From: PETER SHAW <[REDACTED]>
Sent: 16 October 2019 11:54
To: Juan Baeza <[REDACTED]>
Subject: Re: Gladwyn - East Preston

Further to this morning's meeting at Gladwyn, The Street, East Preston, I can confirm that I am satisfied with the proposed parking provision of 9 spaces as per revised plan provided by Mr Shaw on Friday (11th October).

TITLE: Swept Paths March 2018 SITE: Limetree Close East Preston	Drawing: Vehicle Swept Paths	Autoturn Vehicle Swept Path Analysis & Visibility Data Prepared by Autoturn Specialists in Simulated Vehicle Swept Paths
	Drawing Reference: LT.SWEPT.001	
	Scale: On A2 1:200 / as bar

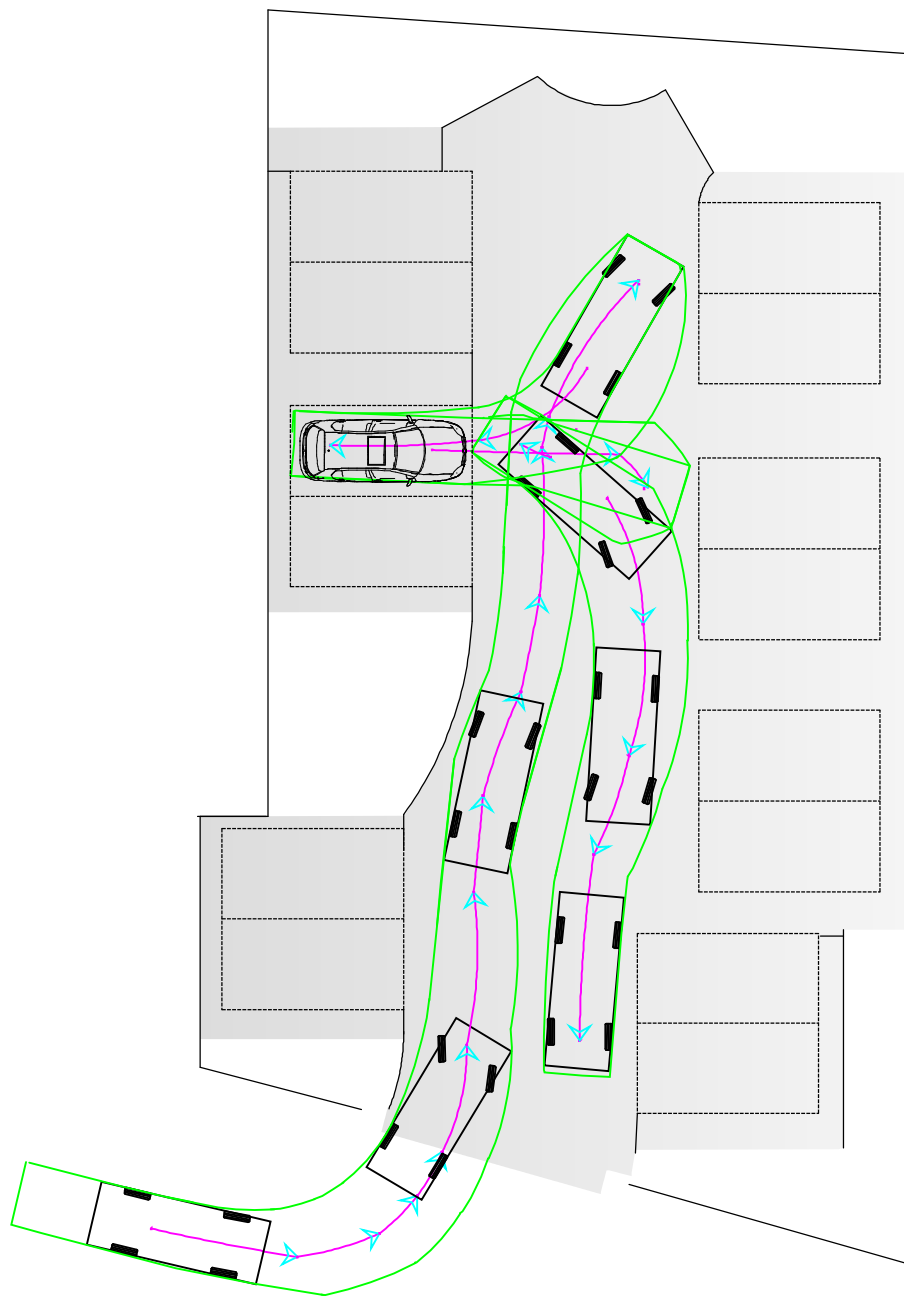
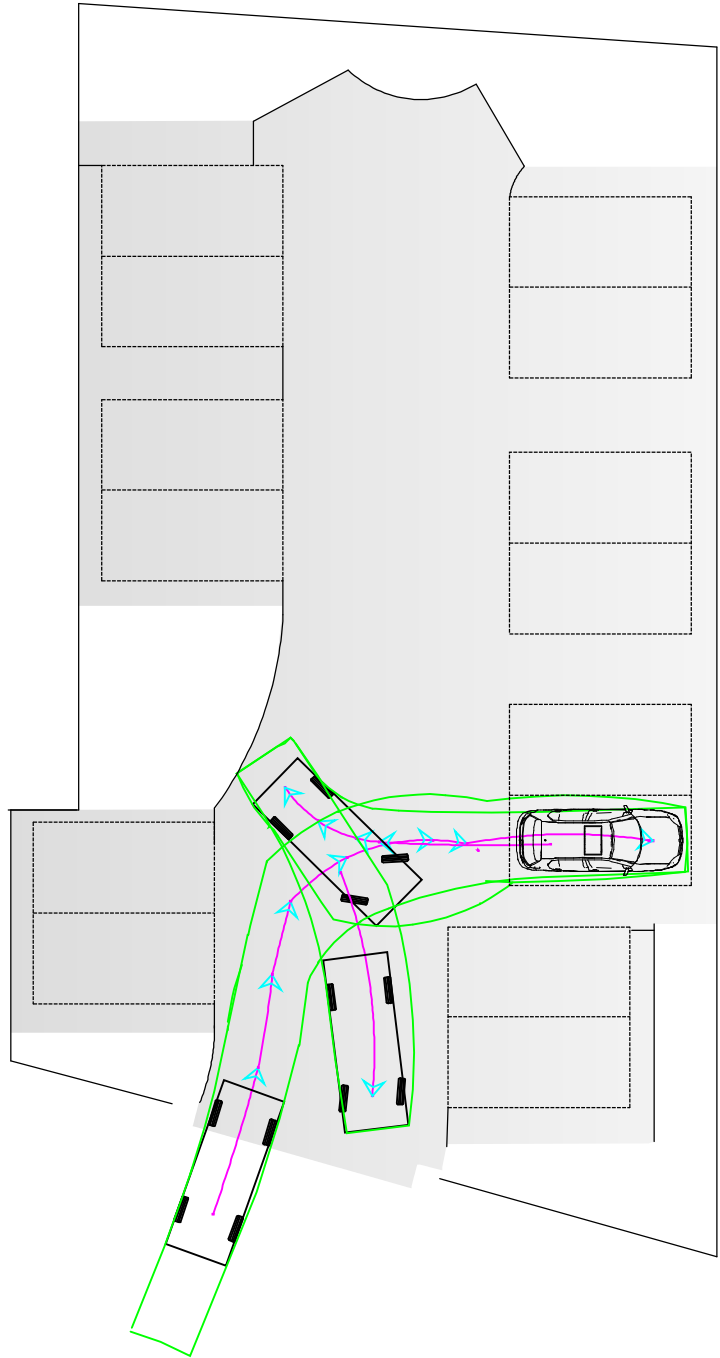
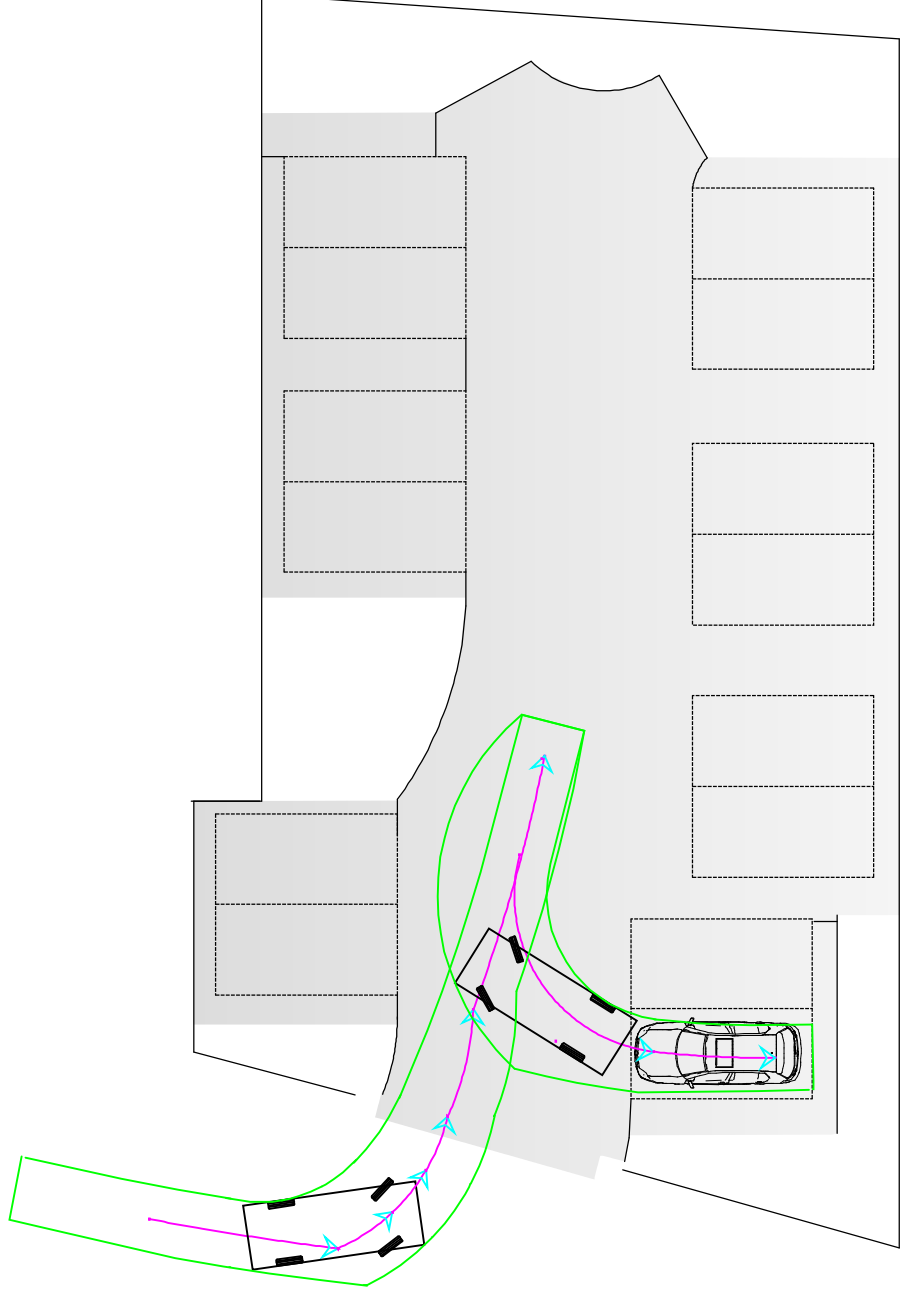
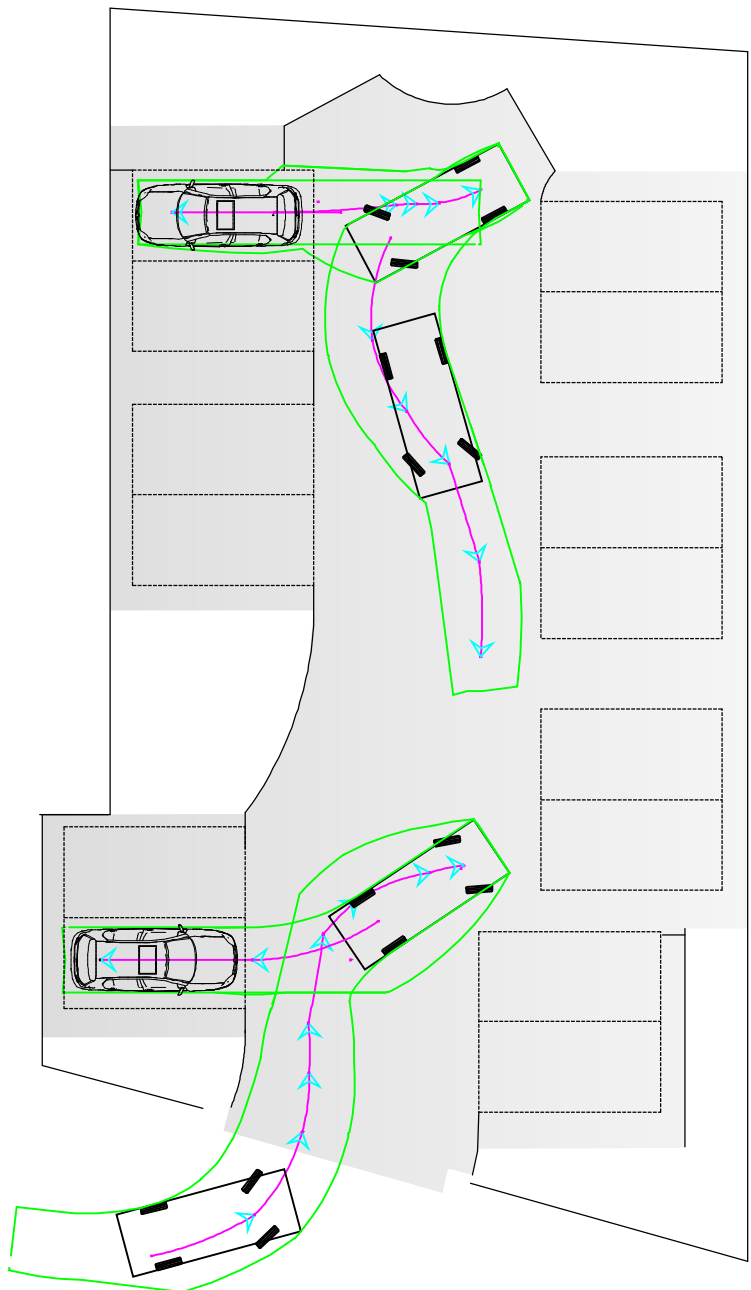
I can confirm that 9 spaces meets the minimum requirements for allocated parking provision, i.e. 2 spaces allocated per dwelling and 3 overspill/visitor parking spaces. I understood from Mr Shaw that he intends to retain unallocated provision, in which case, the proposed provision exceeds the minimum requirement of 7 unallocated spaces.

With regards to the boundary wall, we measured visibility on site at a distance of 2.4m back from the carriageway edge. In the leading direction (to the north of the access) 43m visibility is achievable in accordance with Manual for Streets (MfS) standards, without any alterations to the existing wall required. In the trailing direction (to the south), visibility is obstructed by the wall and overgrown hedges.

The current height of the boundary wall is 1.2m. We discussed two options on site, firstly the reduction in height of the wall, and secondly relocating the wall within the site. In its current position, due to the proximity to the school, we would require the wall to be reduced in height to 600mm to allow visibility of small children. However, we did agree on site that a compromise could be reached and we would support the wall being reduced in height to 800mm. This option would still result in some loss of the wall. We then discussed the option of repositioning the wall to a set-back of 0.5m from its current position. It was agreed by all that this would be the favoured option as it is anticipated to provide a full unobstructed visibility splay of 43m to the south and would not result in any loss of the flint wall.

Subject to a revised plan confirming that a 0.5m set-back would provide the required 43m splay to the south, I would not consider that this proposal would have an unacceptable impact on highway safety or result in 'severe' cumulative impacts on the operation of the highway network, therefore is not contrary to the National Planning Policy Framework (paragraph 109), and that there are no transport grounds to resist the proposal.

Thank you for the meeting today and for your help. Please see the attached revised drawing showing the garden wall rebuilt some 500mm into the garden.

I would like to retain the Southern most brick pier as it defines the 2 boundaries of the plot and should not affect visibility. The final decision on this can be made once we start site clearance and can properly set things out.
